| <b>Urban Design Observations</b> |                                   |                      | <b>Officer:</b> | <b>Stephen Kilmartin</b>                                                                                                                                                                             |
| <b>Description:</b>              | Land off Henthorn Road, Clitheroe |                      |                 |  <b>Ribble Valley<br/>Borough Council</b><br><a href="http://www.ribblevalley.gov.uk">www.ribblevalley.gov.uk</a> |
| <b>Application Ref:</b>          | 2017/0433                         | <b>Case Officer:</b> | S.K             |                                                                                                                                                                                                      |
| <b>Response Ref:</b>             | 2017/0433/UD/01                   | <b>Issue Date:</b>   | 01/08/17        |                                                                                                                                                                                                      |

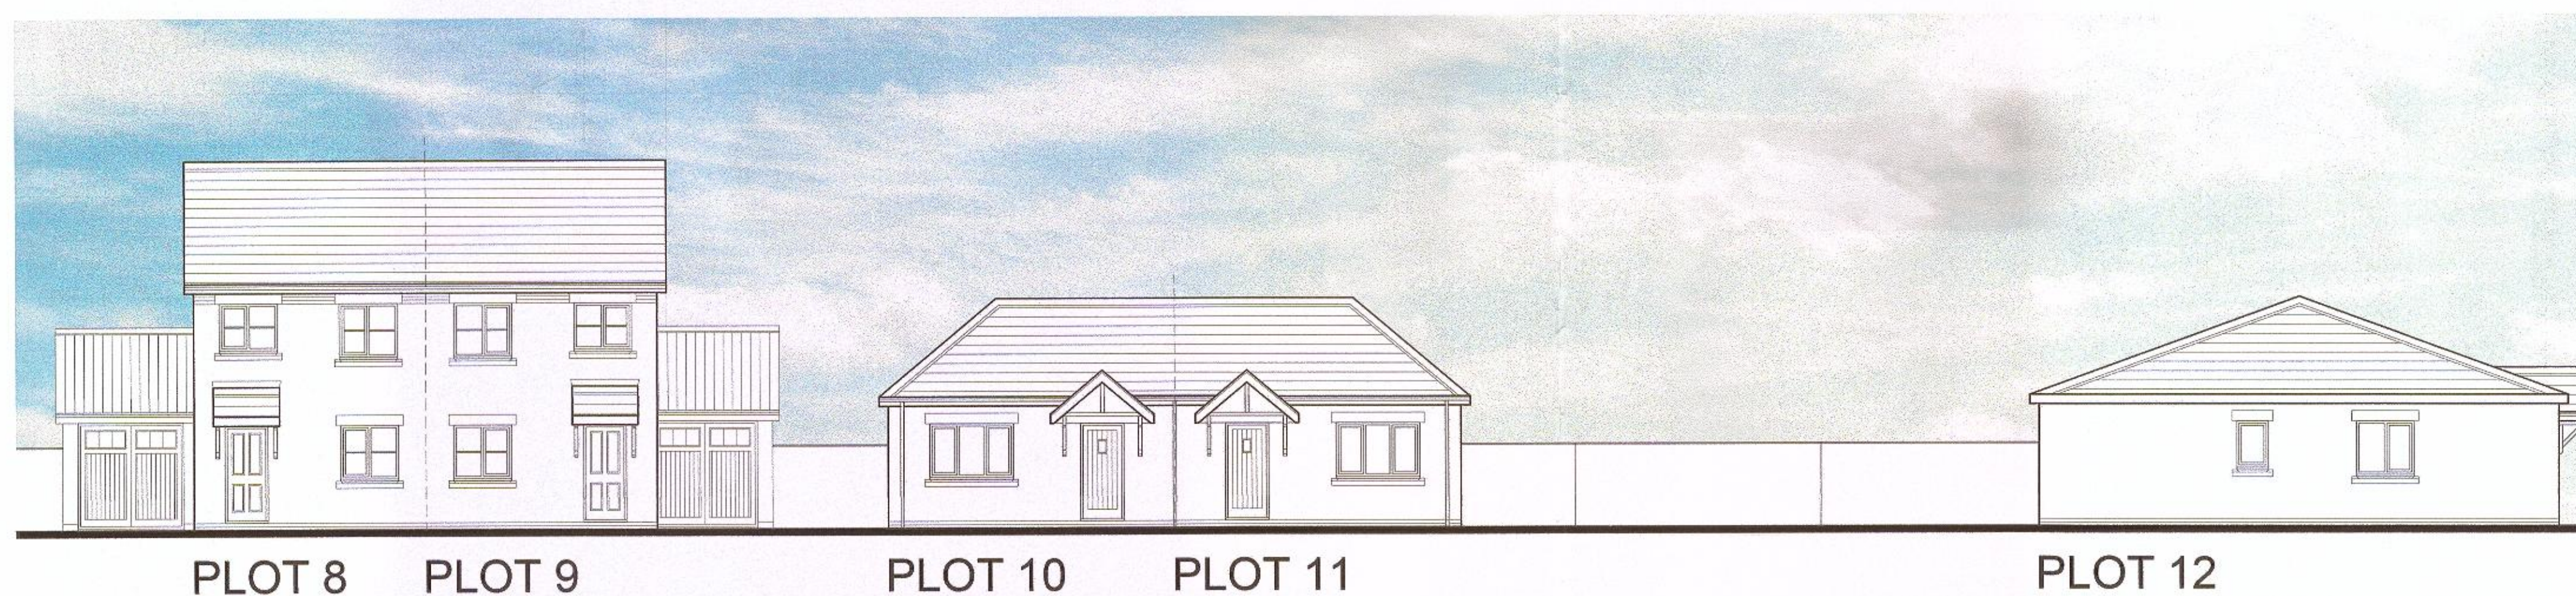
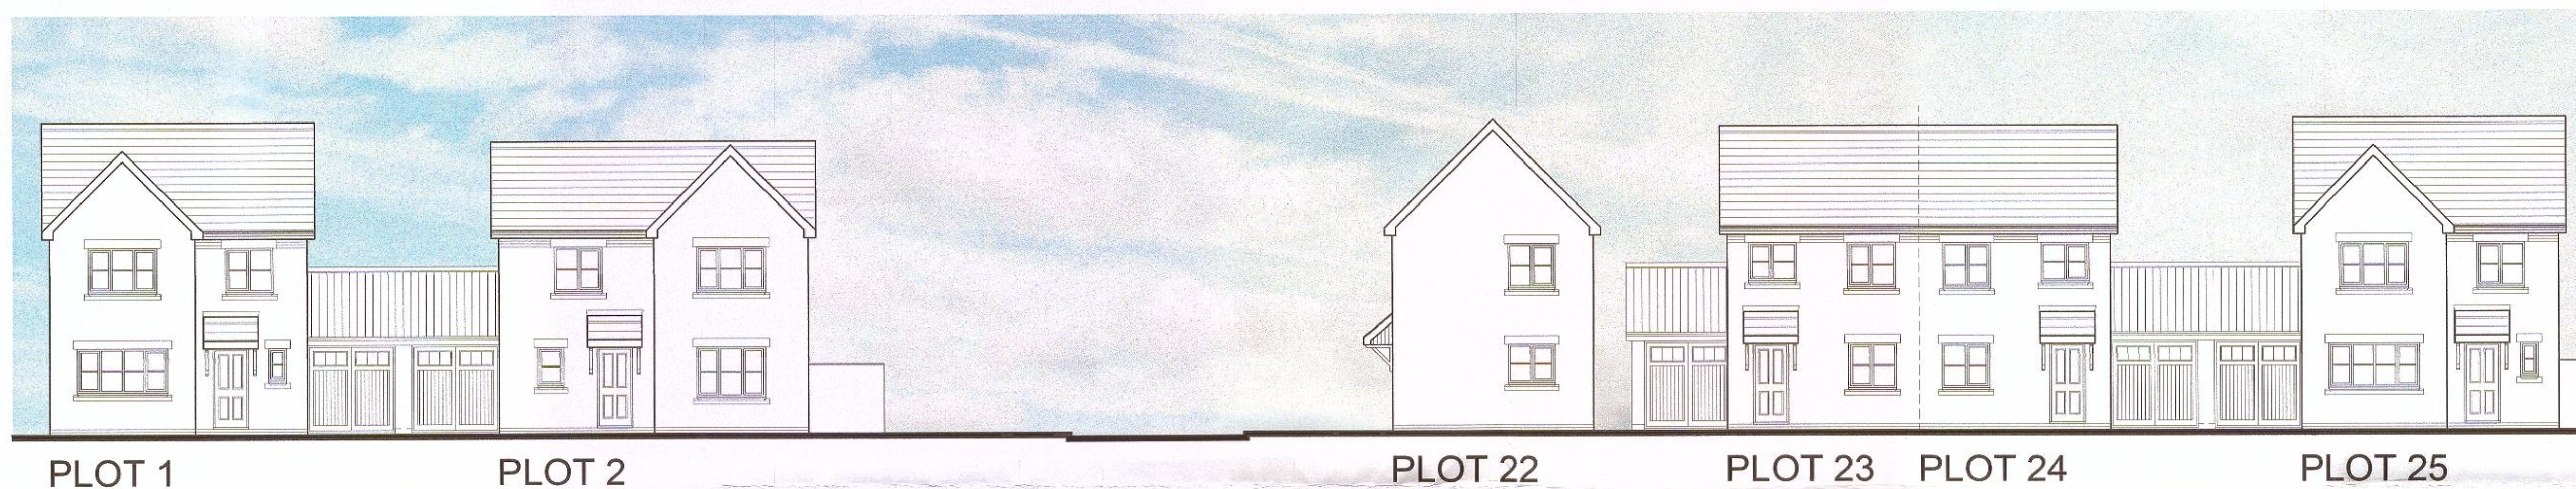
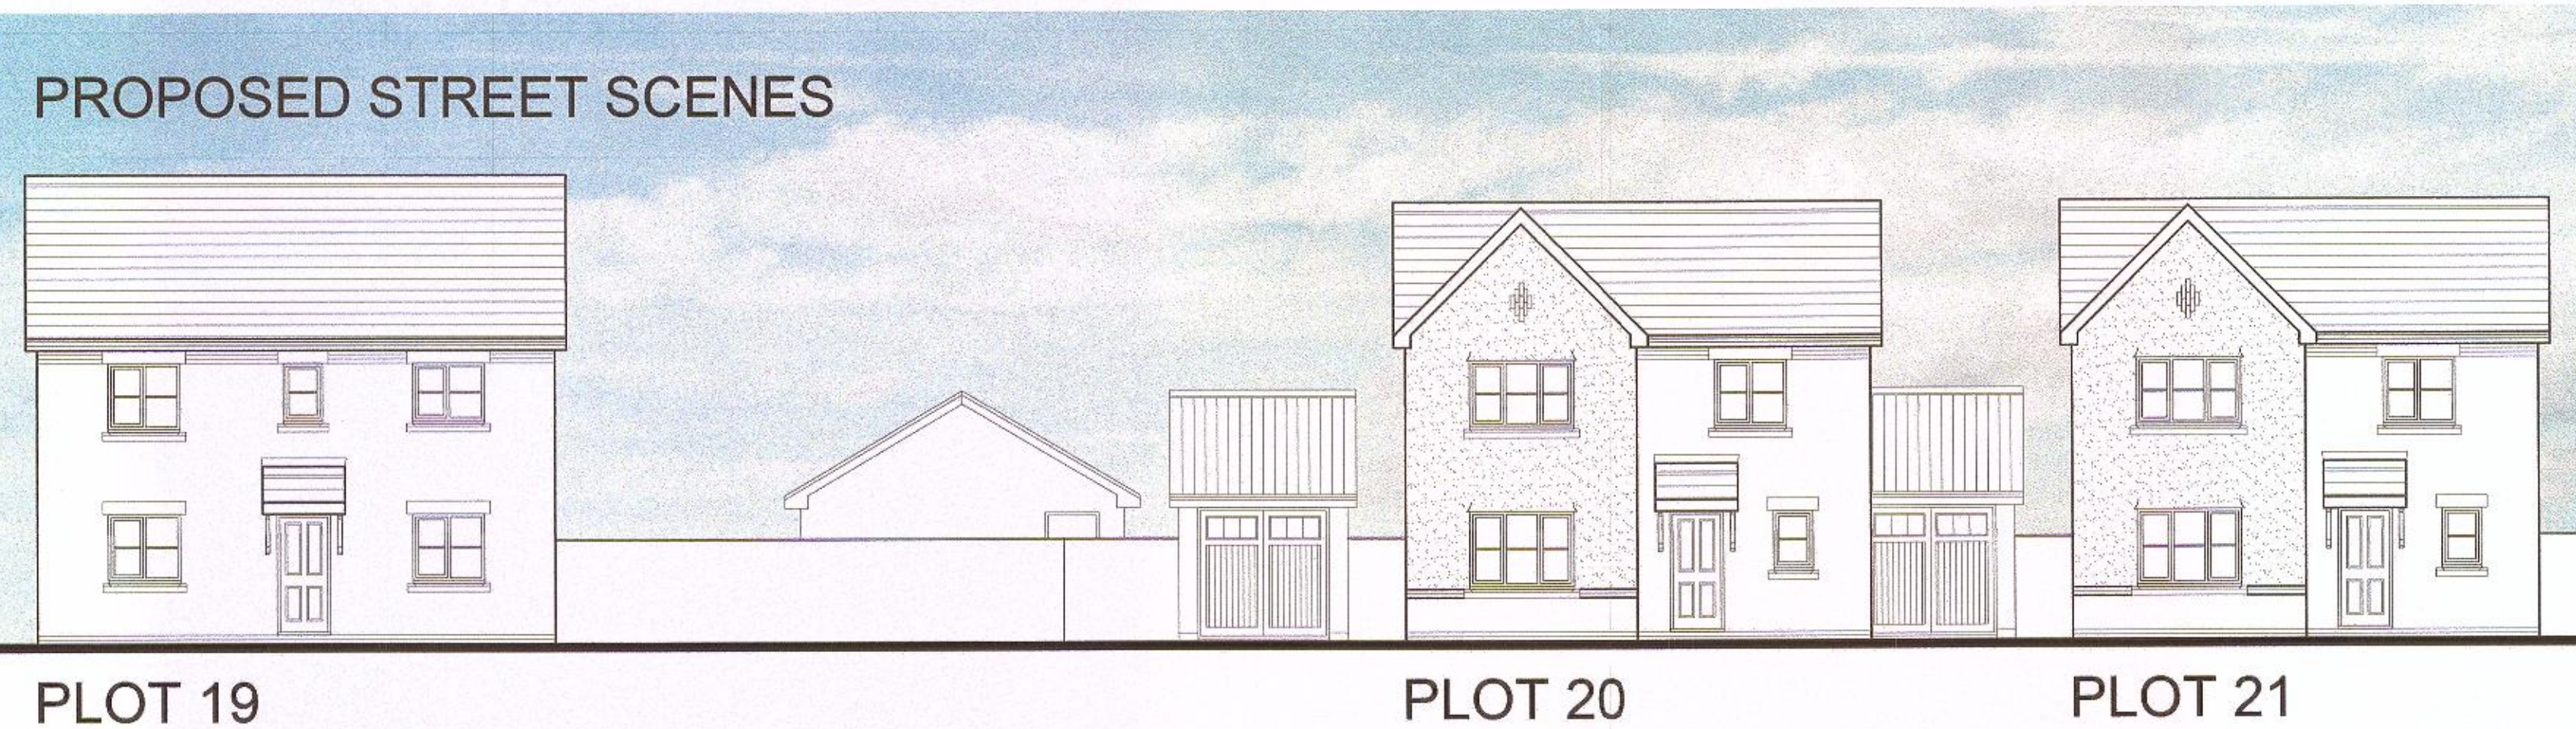
| <p><b>4.1</b></p>             | <p>Whilst I accept that the submitted house types and street scenes are illustrative only I have a number of concerns in respect of the proposed external appearance of the dwellings and also concerns in respect of the supporting information contained within the Design &amp; Access Statement relating to the</p>                                                                                                                                                                                                                                                                                                                                                                                                                                                                                                                                                                                                                                                                                                                                                                                                                                                                                                                                                                                                                                                                                                                                                                                                                                                                                                                                                                                                                                                                                                                                                                                   |

- Given the peripheral location of the site and its direct interface with the defined open countryside I do not consider that red-brick to be appropriate as a primary facing material given it usually has more 'urban connotations'. I consider that limiting the materials palette to that of render and stone/reconstituted stone will allow the development to be more successful in reflecting visually, the rural context of the site.

- I welcome the inclusion of artstone heads and sills but would also request that the use of artstone jambs/surrounds also be considered.
- Roof animation/articulation should be considered with variation in the roof scape provide through the introduction of chimney stack detailing on a number of key plots including those that may benefit from an outward aspect into the defined open countryside.

- Explore the opportunity to adopt a more semi-rural architectural language that would more successfully reflect the landscape context of the site.
- I have enclosed a small number of sketch elevations to convey the above points.

2741-101 Tree Survey

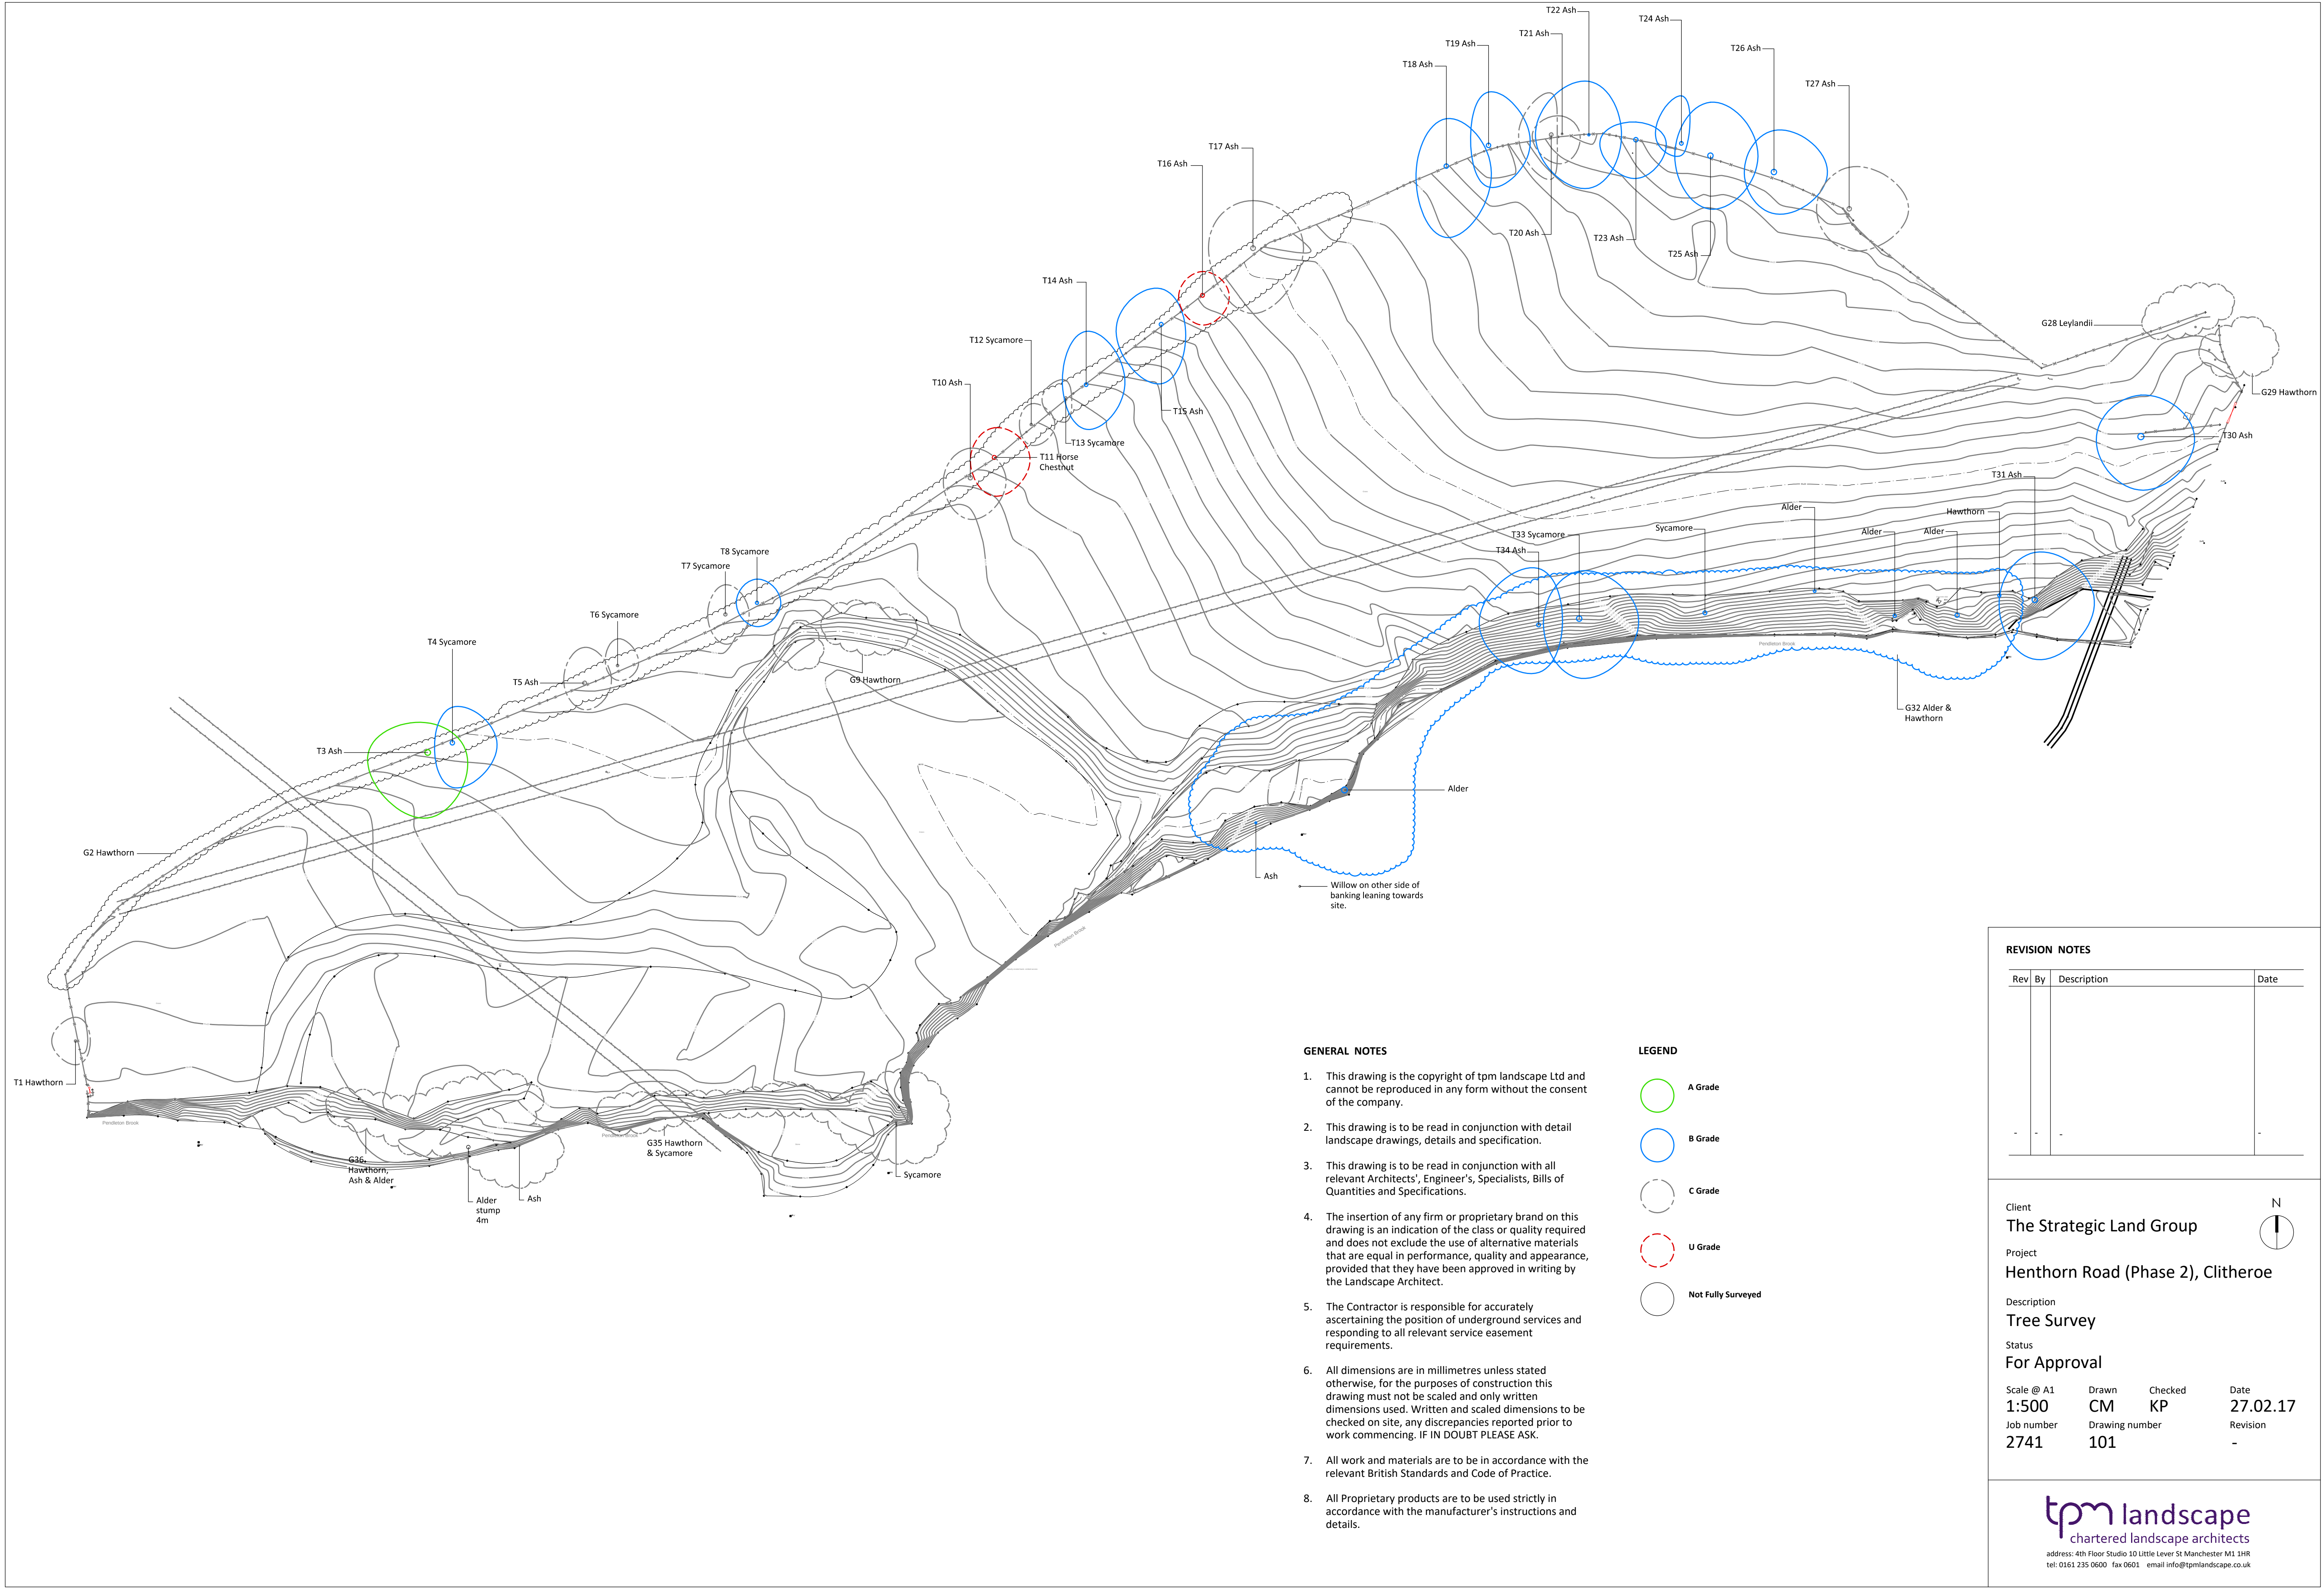
- 2.9** Due to the presence of well-established linear landscape features and their proximity to the watercourse it is highly likely the area has significant value as an area for foraging birds/bats, therefore the potential to accommodate nesting/roosting provision upon buildings exists and such provision should not solely be limited to tree mounted provision as recommended within the report. In this respect, taking account of the location of the proposed site, the Local Planning Authority would seek to secure a 1:1 ratio of bat/bird box/brick provision upon each dwelling, the locations of which to be recommended by a licenced ecologist. I would therefore request a commitment at this stage to provide provision at the aforementioned ratio or alternative provision which results in an equatable level of habitat enhancement/uplift.
